Development Facilitation Team (DFT) – Review Comments

DRB Project No: PR-2020-003484 Date: 05/24/2023 Agenda Item: #4 Zone Atlas Page: E-10

Application For: SD-2023-00048 – PRELIMINARY PLAT (DHO)

SUBJECT: Preliminary Plat

PRELIMINARY PLAT FOR  
**MOJAVE RIDGE SUBDIVISION**  
 (A REPLAT OF LOTS 2 & 3, BLOCK 12,  
 UNIT 3, VOLCANO CLIFFS SUBDIVISION)  
 WITHIN  
 SECTION 27,  
 TOWNSHIP 11 NORTH, RANGE 2 EAST, N.M.P.M.  
 CITY OF ALBUQUERQUE  
 BERNALILLO COUNTY, NEW MEXICO  
 JANUARY, 2023

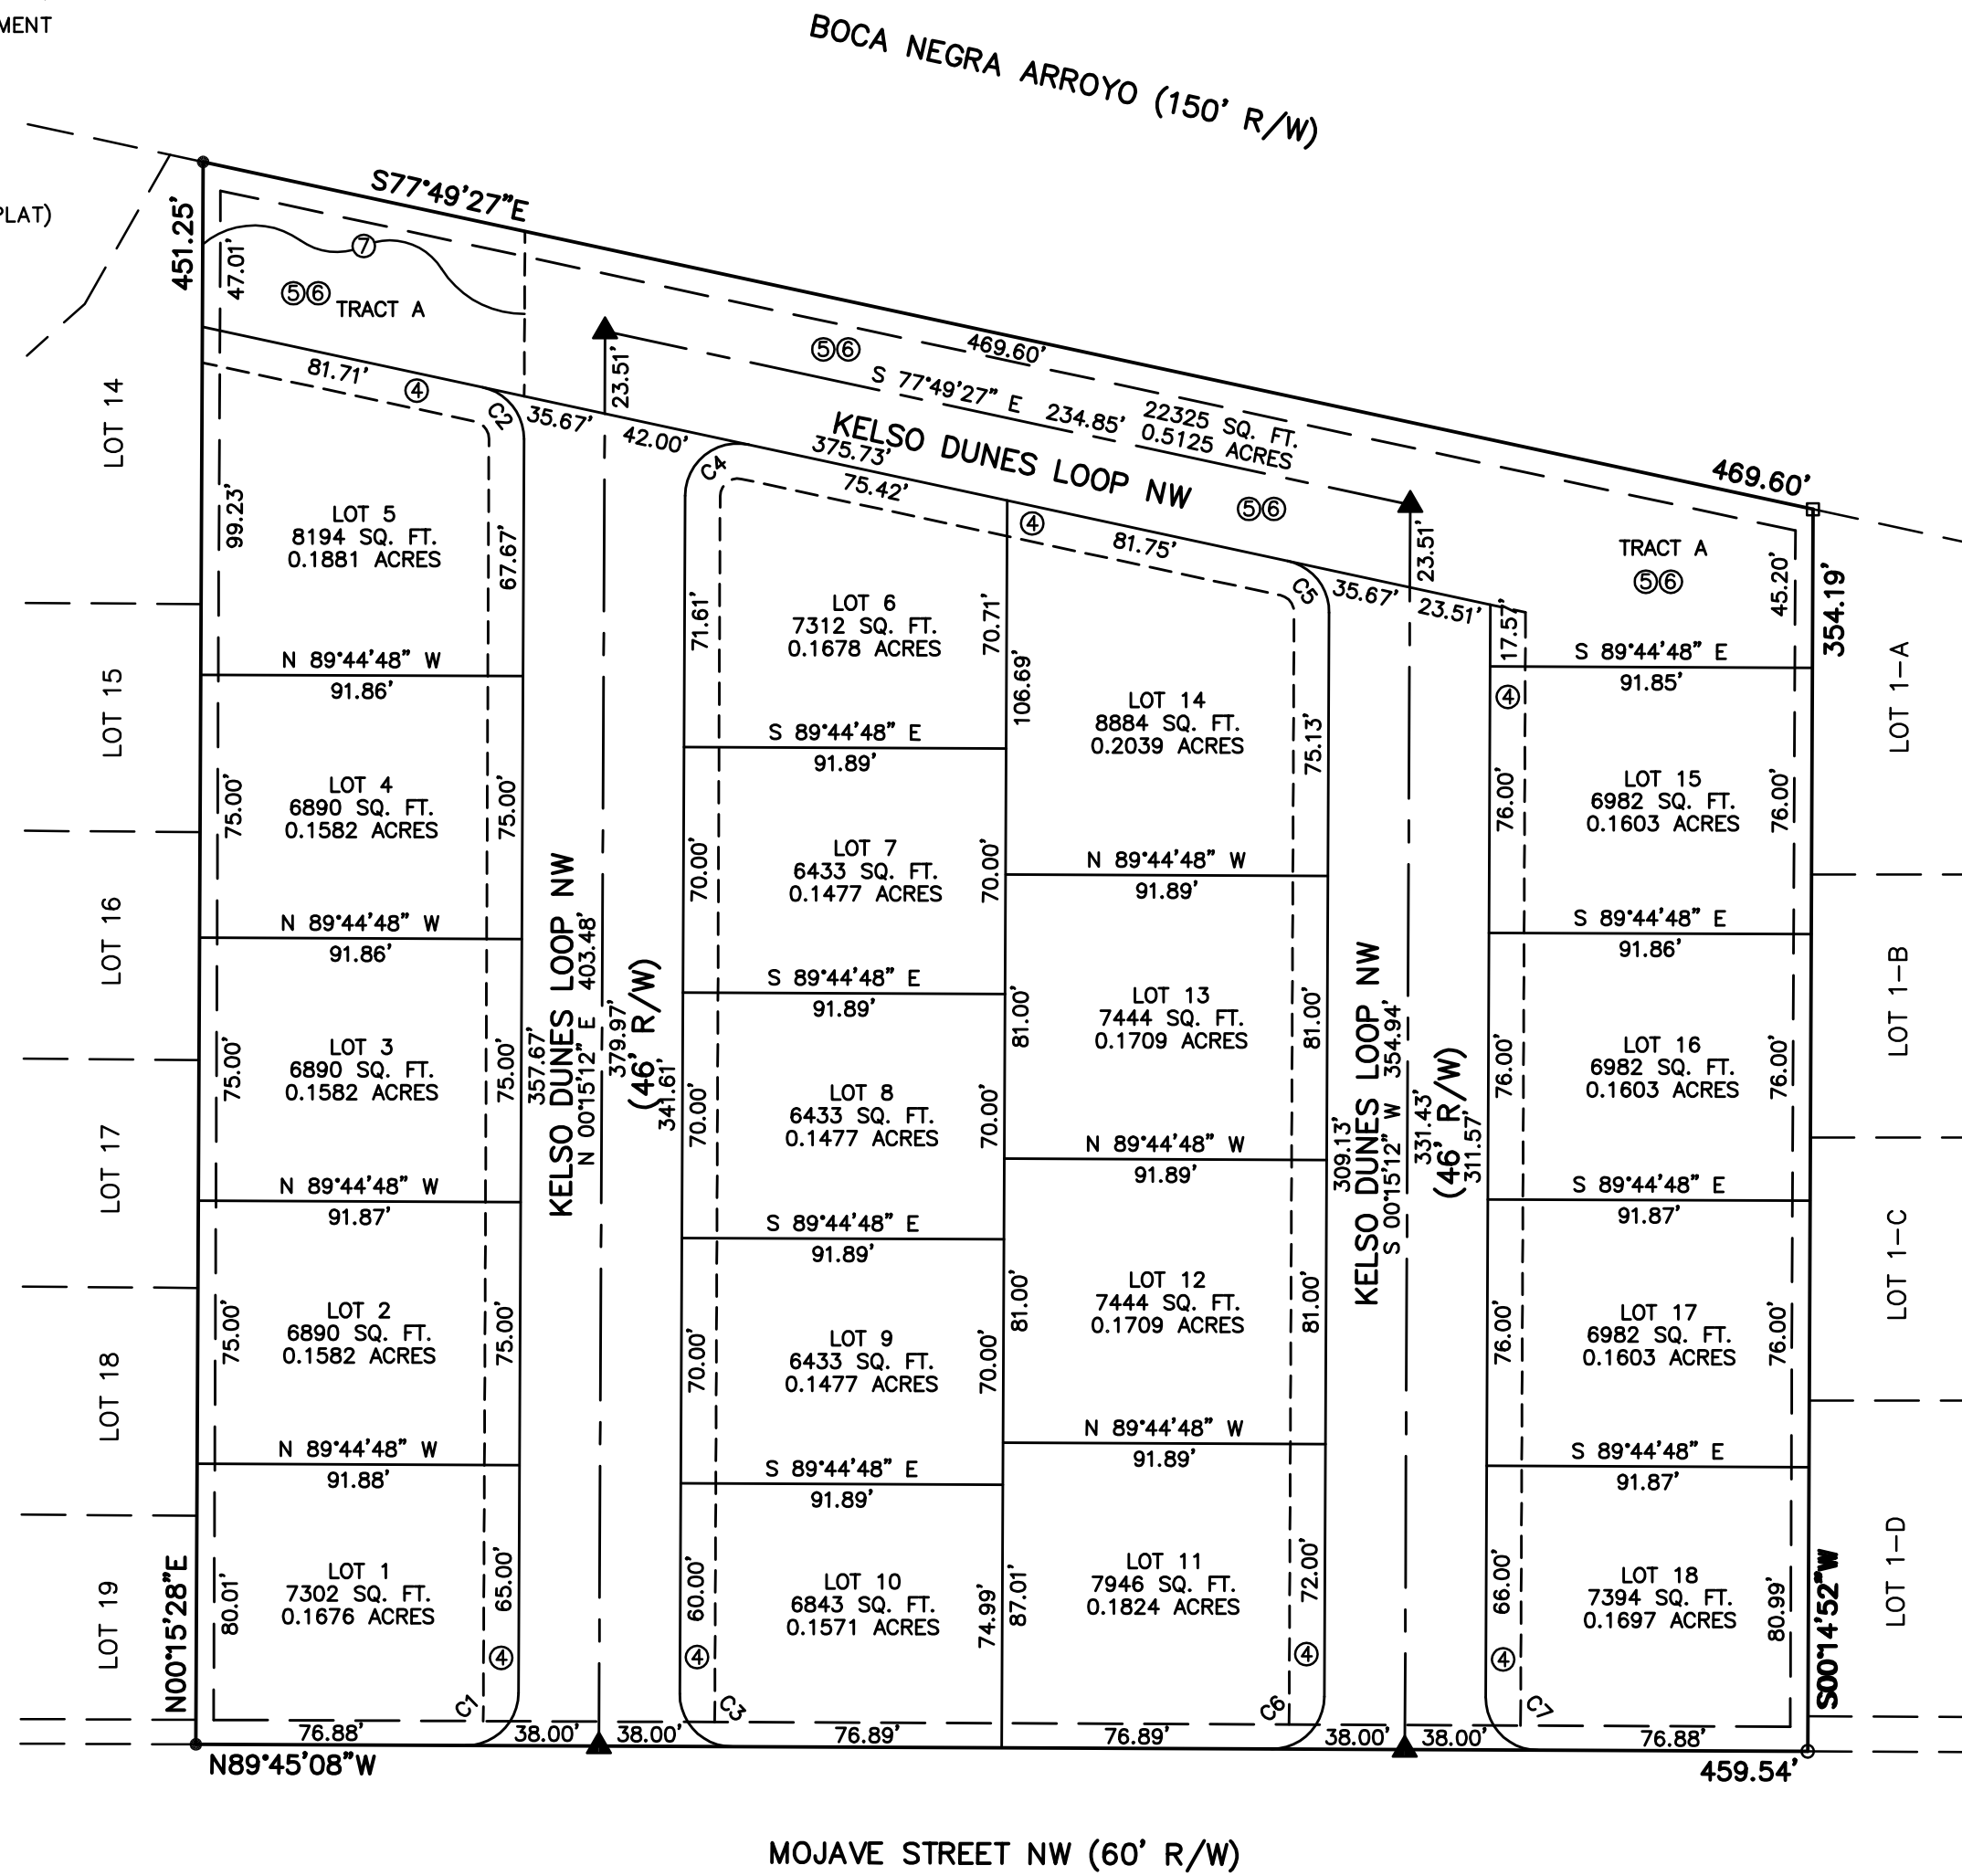
1. I do not see the latest plan that shows Colton St. as a separate tract in order to keep the scour wall out of the ROW. Please ensure this has been done and that this will be on the plat that we are approving or that the scour wall is outside of the ROW.
